OFFICIAL NOTIFICATION OF DECISION

Project# #PR-2019-002519

SD-2019-00193 – VACATION OF RIGHT-OF-WAY

PLAT OF
LOT 1-A-1 BLOCK "A"
ANDERSON & THAXTON'S REPLAT OF A PORTION OF
TORREON ADDITION
WITHIN
TOWN OF ALBUQUERQUE GRANT
PROJECTED SECTION 17, TOWNSHIP 10 NORTH, RANGE 3 EAST, N.M.P.M.
CITY OF ALBUQUERQUE
BERNALILLO COUNTY, NEW MEXICO
MAY 2020

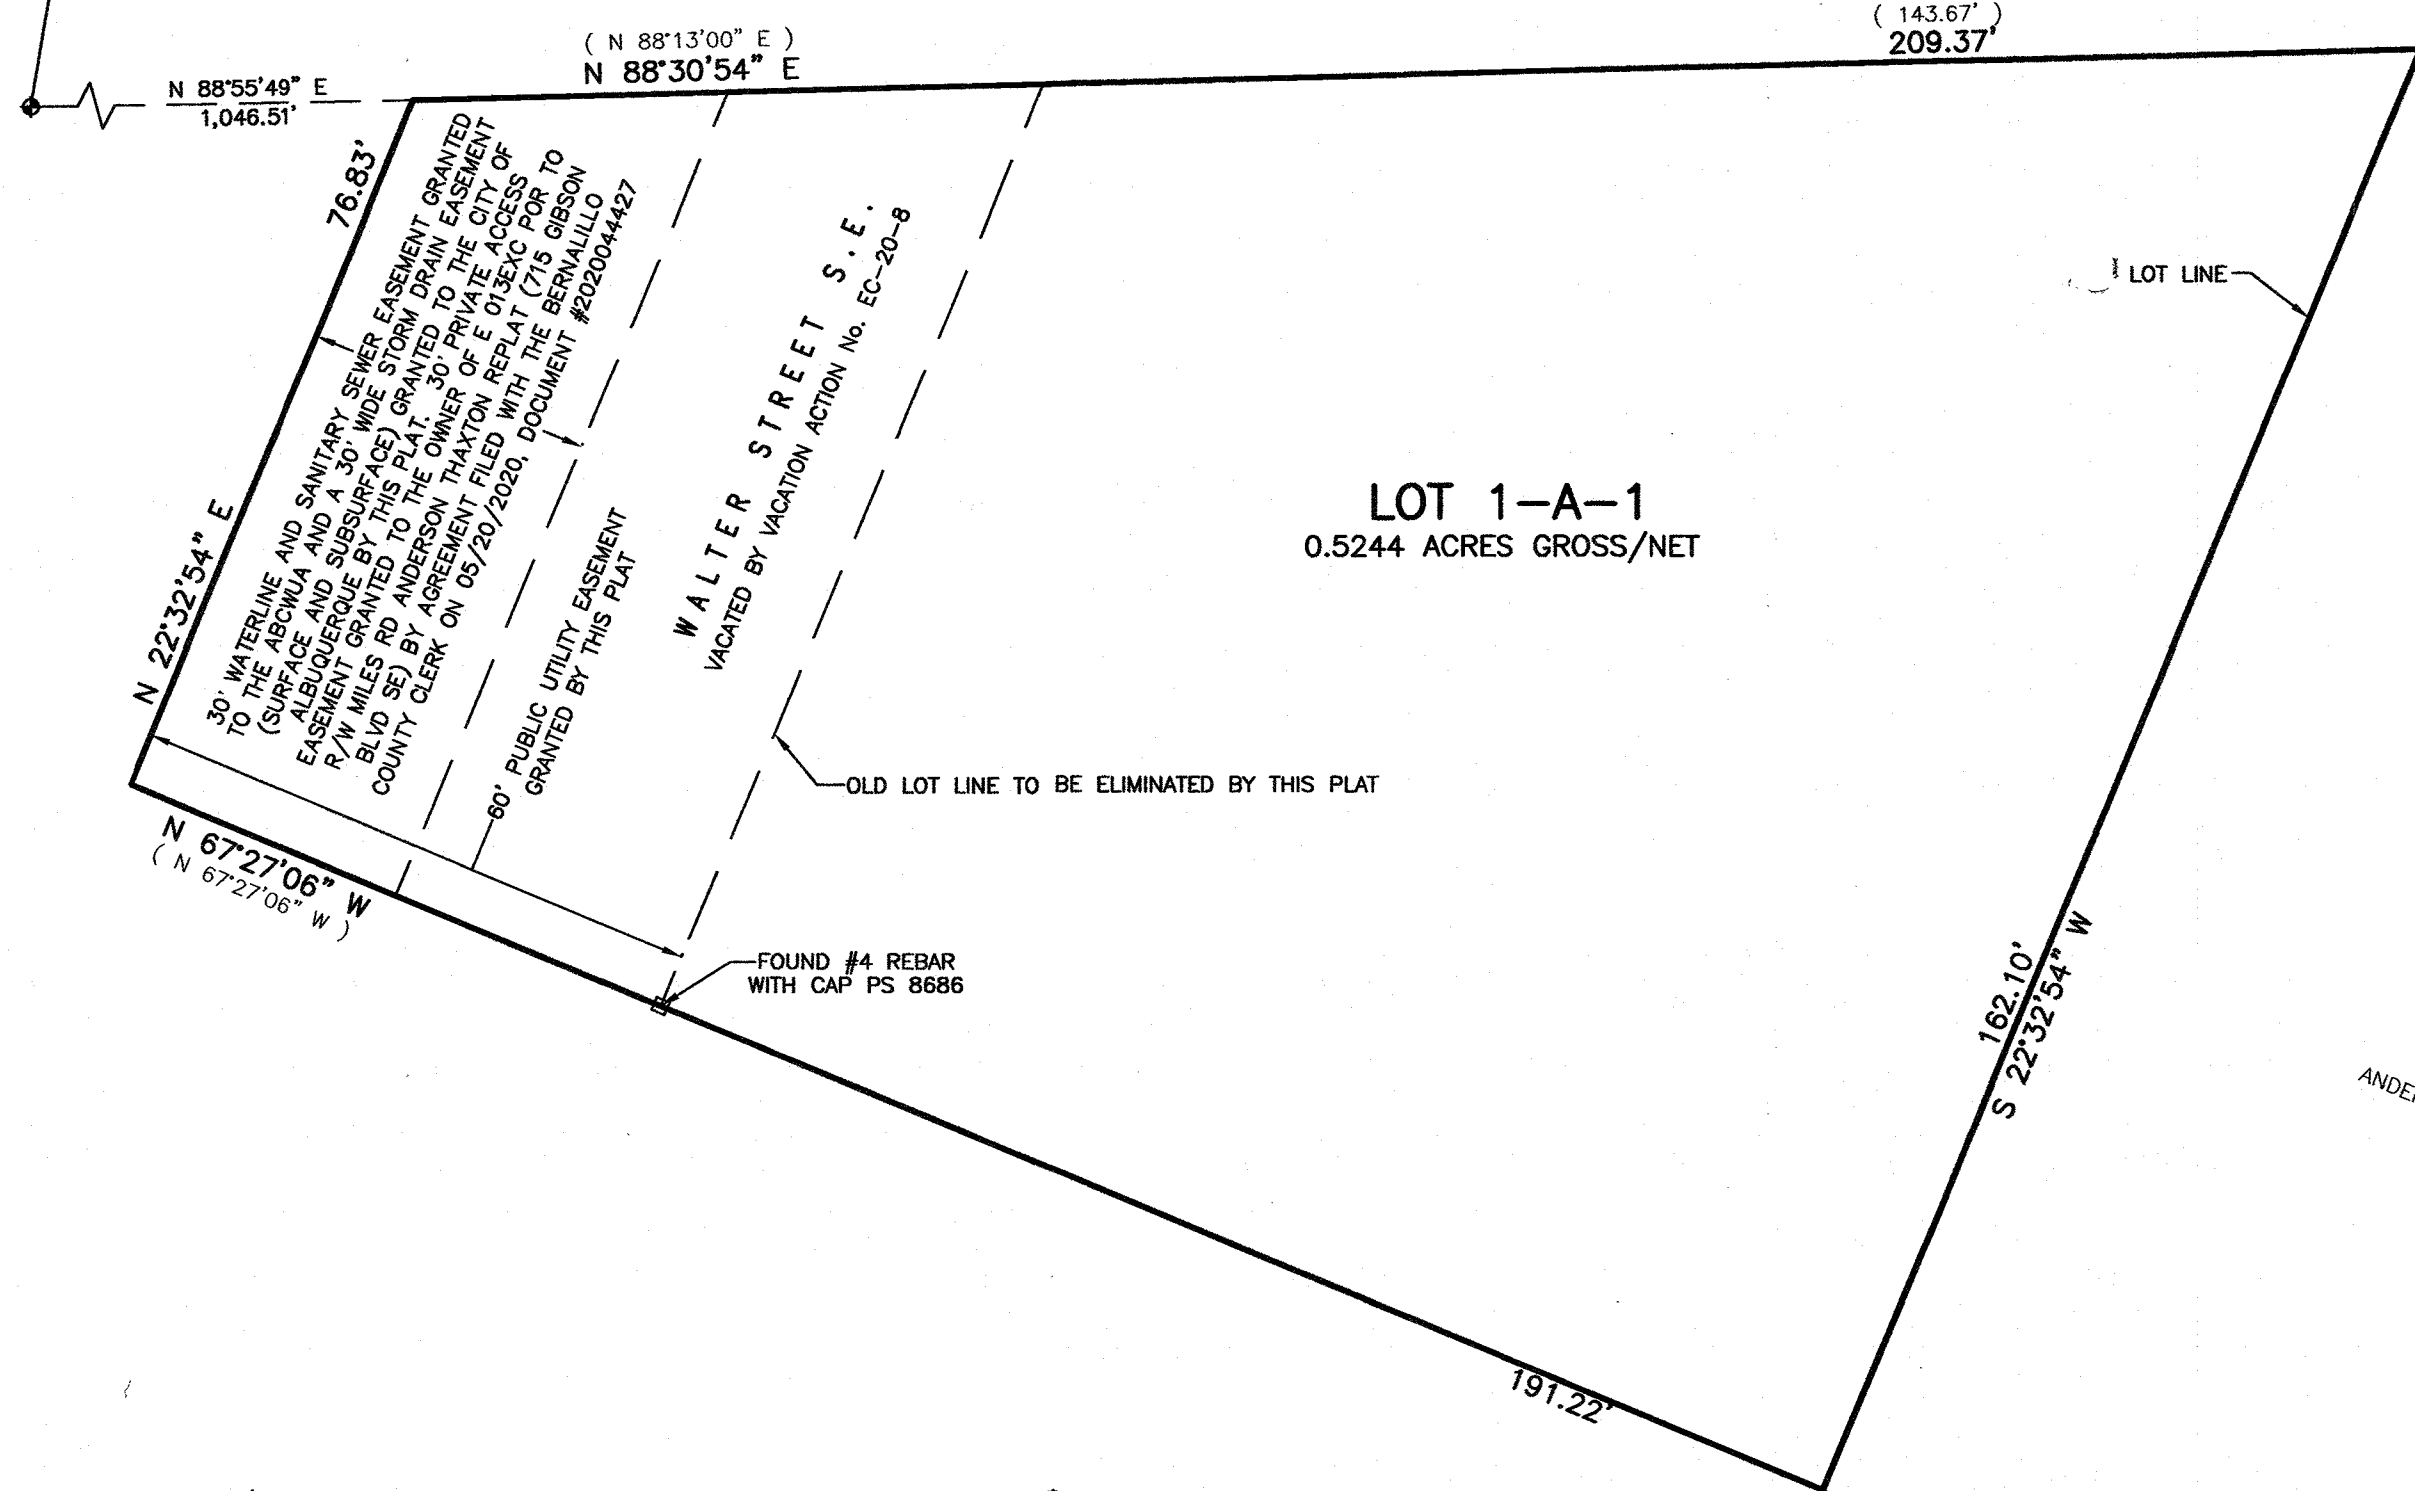
1. Final sign off is delegated to Planning to check for the correct spelling of Walter street.
2. A replat showing the vacated property must be approved by the DRB and recorded within one year of City Council approval.
3. Conditions from ABCWUA including an access easement to the well site and utility easement must be addressed prior to final sign off.
4. Drainage easement must be shown on final plat

EXHIBIT OF
**VACATED PORTION OF
 WALTER STREET S.E.**
 BERNALILLO COUNTY, NEW MEXICO
 OCTOBER, 2019

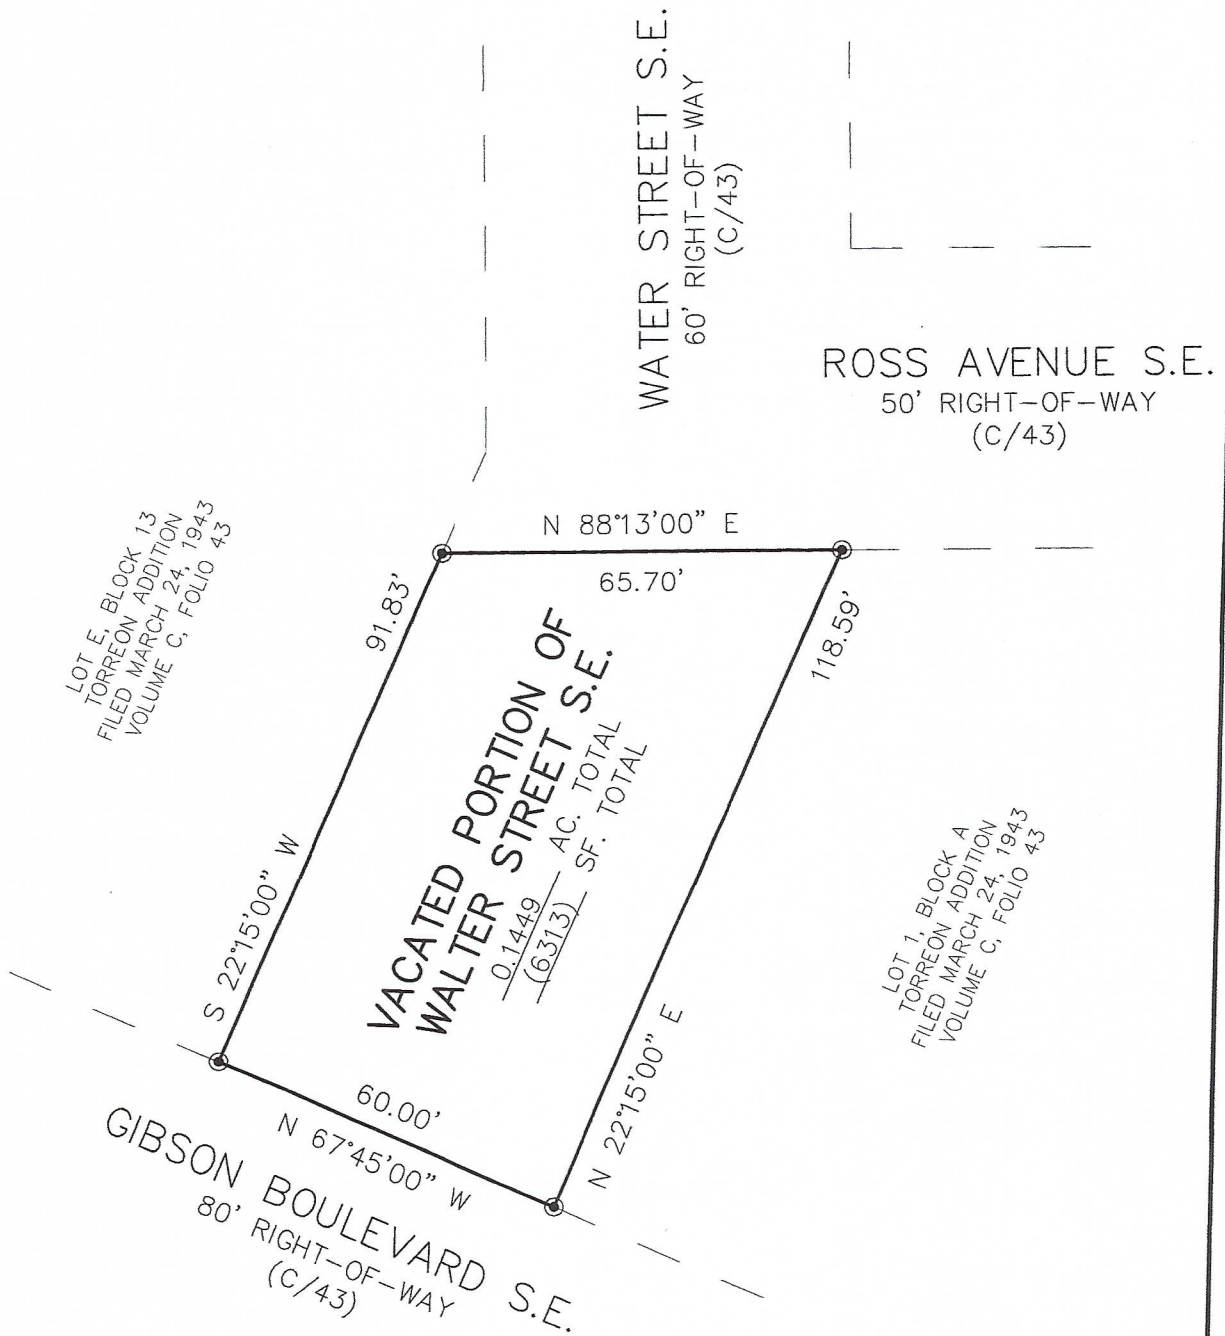
1. This is a request to vacate the entire width of Walter Street SE (6,313 square feet) between Gibson Boulevard SE and Ross Avenue SE as shown on the vacation request exhibit.
2. Pursuant to section 14-16-6-(K)(2)(e), the DRB will make a recommendation to City Council on the request because the vacation contains the entire width of a road.
3. The applicant provided notice as required in table 6-1-1 of the IDO.
4. Vacation requests must meet the criteria in IDO Section 14-16-6-6-(K)(3)(a): *The public welfare does not require that the public right of way or easement be retained:* The public welfare does not require that the right-of-way be retained because there is no existing access to Gibson Boulevard via Walter Street. The applicant will provide the required easements to allow the ABCWUA access to their property on Walter Street.
